Sussex Police
Serving Sussex

Our Ref: NW/ARU/18/02A

RE. Land East of Windy Ridge Mayflower Way Angmering BN16 4AY

Thank you for your correspondence of 22nd January 2018, advising me of a planning application for 12No.Social dwellings for Angmering Community Land Trust, including two communal bike stores, a pedestrian mews and orchard. Departure from the Development Plan, for which you seek advice from a crime prevention viewpoint.

Bicycle Shed 1 - Section and Elevation

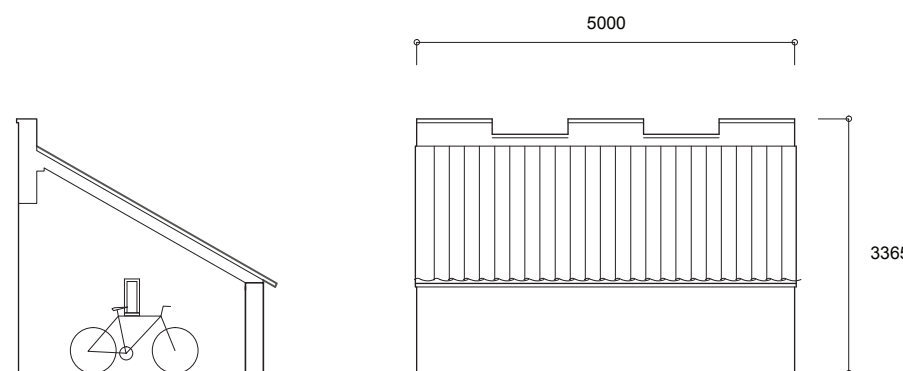
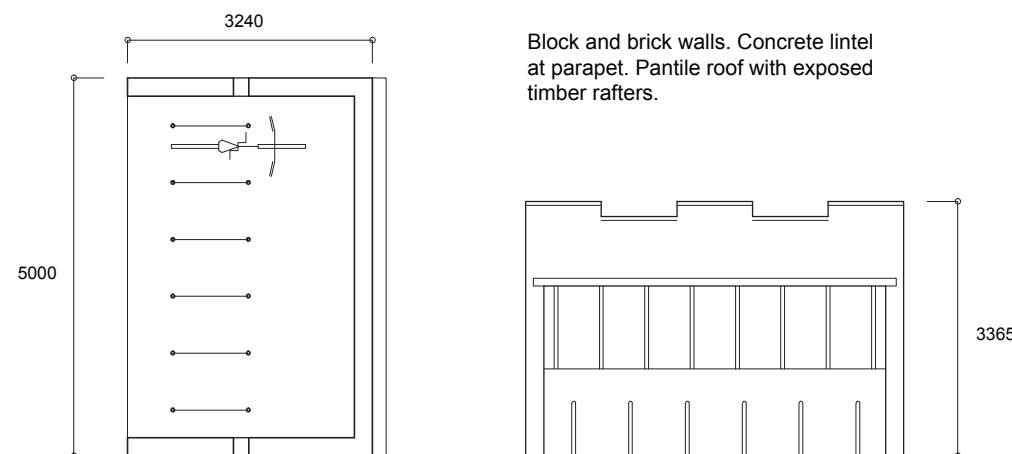
I have concerns regarding the type of open sided cycle storage in Mayflower Mews especially the store closest to Mayflower Way .They may be subject to crime from individuals using Mayflower Way to reach the above location where the BMX bike tracks are located, especially late evenings.

Due to the layout of the proposed dwellings, there is a reduced view of the northern cycle store in particular from the nearest houses, with only units 11 and 12 getting a clear view of the store other than that seen from the road in Mayflower Way.

I would recommend that the cycle stores have solid enclosed walls and a lockable doors for the use by residents. PIR lighting should be installed internally and that the front door should be lockable. A mechanical push button type of lock would be acceptable or a Sold Secure Silver hasp, staple & padlock. If the suggested cycle store has double doors, a door closer should be fitted along with spring loaded automatic shoot bolts to the unlocked door to ensure it closes first.

I direct the applicant to SecuredbyDesign (Homes 2016) Part 3 Paragraph 53 in relation to the secure storage of cycles.
